Urban Design Review Panel Report

1316 Carling Avenue & 1251 Thames Street

Response to UDRP Recommendations

Zoning By-law Amendment Application

Drawing  
**SITE PLAN**

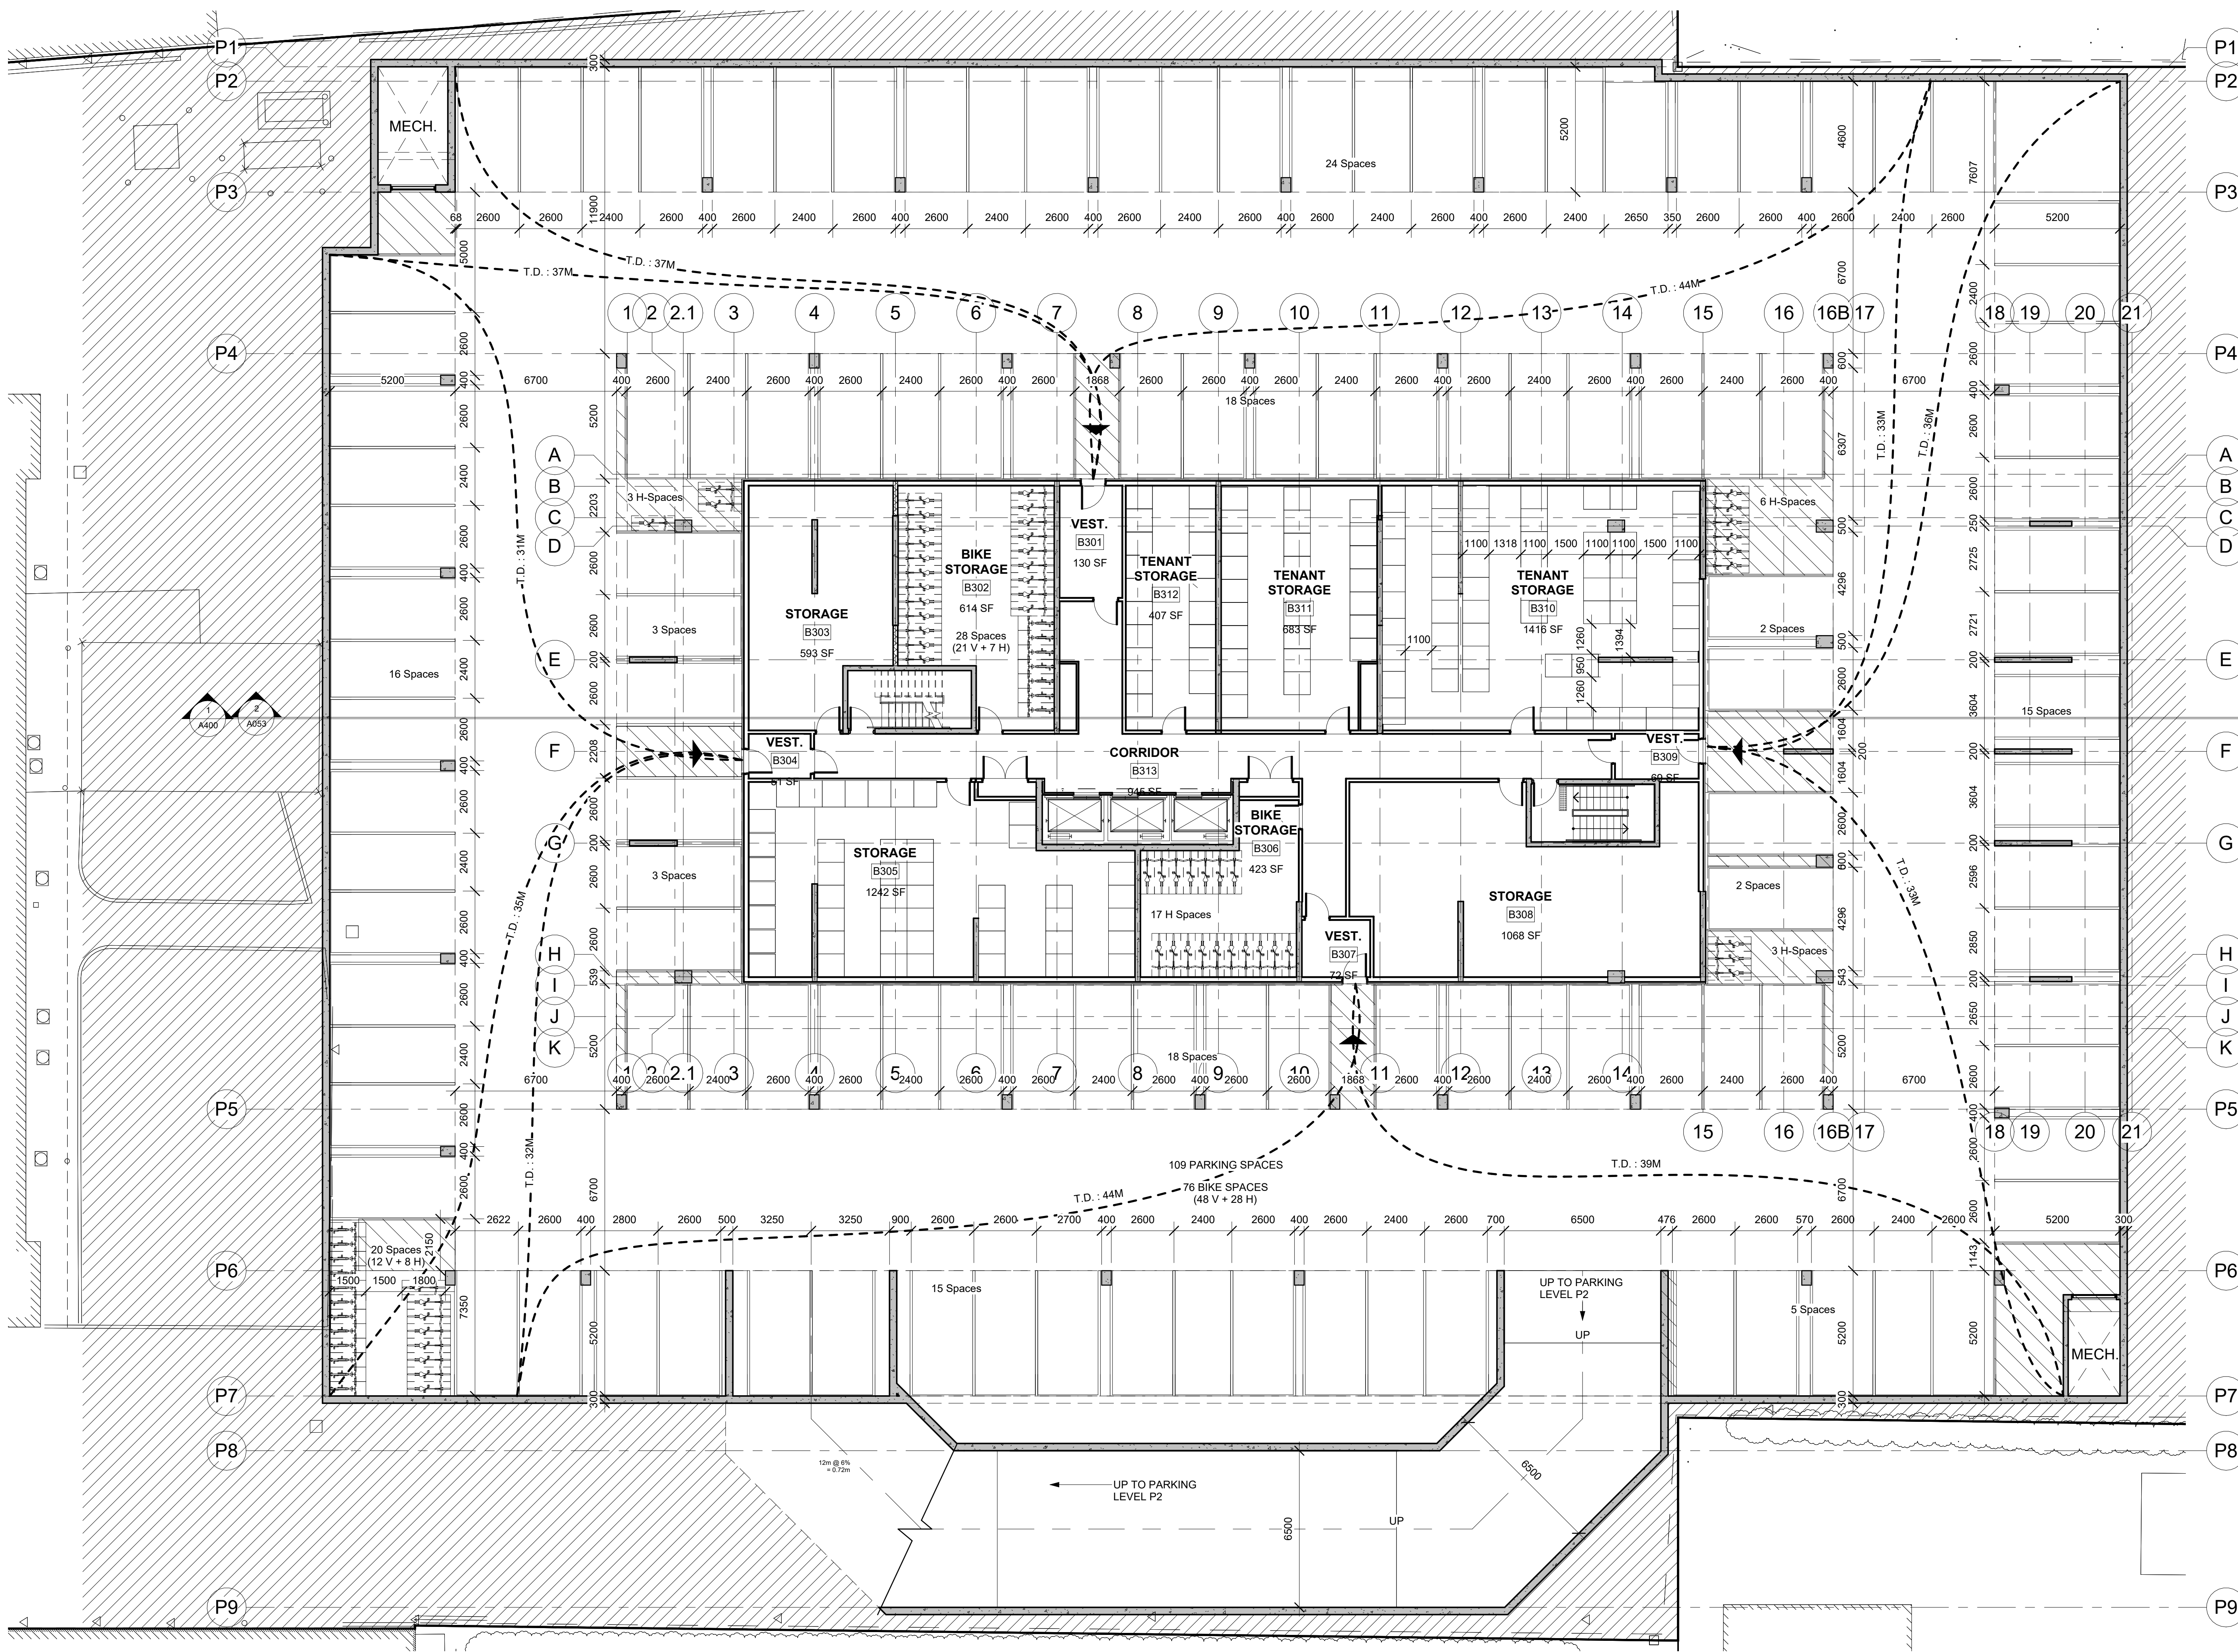
1.3	The Panel notes a concern regarding the amount of site area dedicated to vehicular circulation, encouraging the simplification and consolidation of driveways and surface parking.	Driveways and surface parking have been simplified and consolidated.

No.	Comment	Response
2.3	The Panel encourages the creation of a mid-block pedestrian connection from Carling Avenue to Thames Street as a defining component of the project. This connection must read as a major landscape gesture, providing safe, intuitive, and high-quality pedestrian access through the site.	The mid-block connection has been enhanced along the west border of the site using appropriate landscape and street furniture elements.

2.4	The Panel recommends reshaping vehicular circulation to support this priority, including the possibility of a one-way loop that consolidates access and reduces conflicts.	Existing entrances to the site have been maintained and a new entrance from Thames Street has been created. A one-way loop is not feasible given the shape and dimensions of the site and the need to accommodate emergency and service vehicles .

1 NORTH ELEVATION  
1: 150

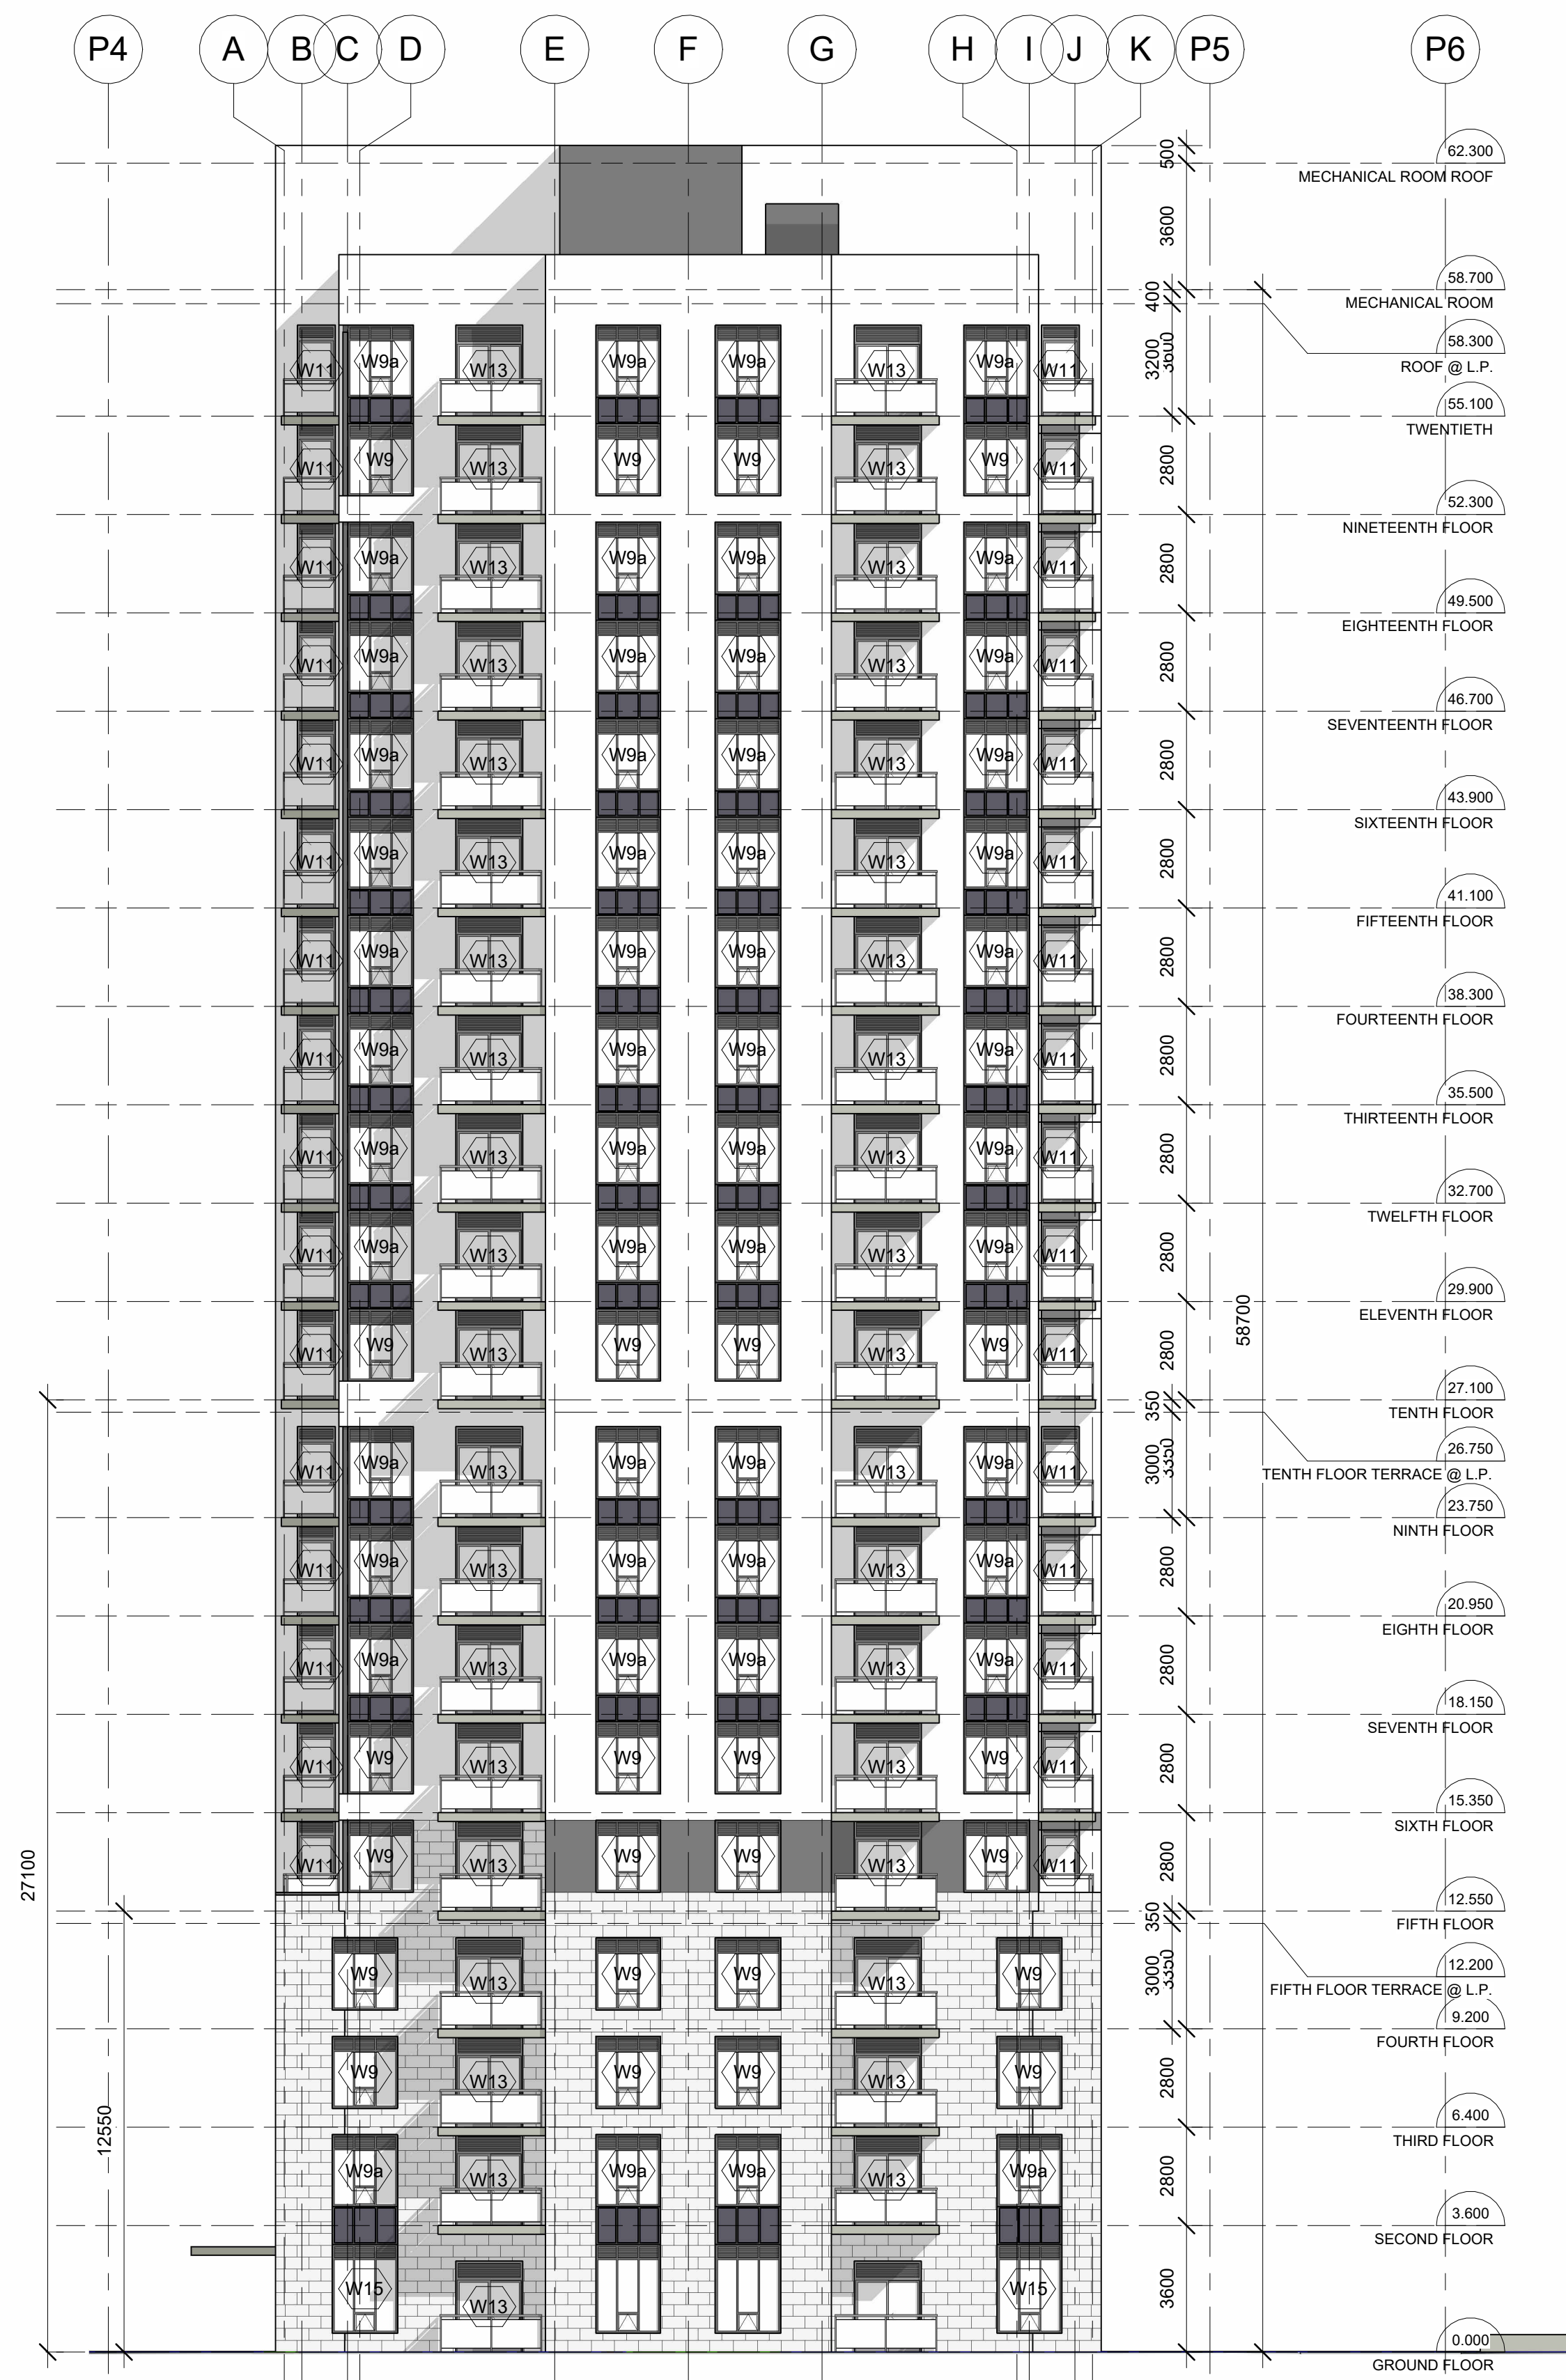
4.5	The Panel recommends refining the base building to provide more texture and human-scale elements. Adding features such as canopies or finer detailing would soften the building's presence at grade and improve the pedestrian experience.	Elevations have been modified to add finer texture and coursing in the base stonework. Window canopies, wall sconces, foundation planter beds and tree boxes have also been added.
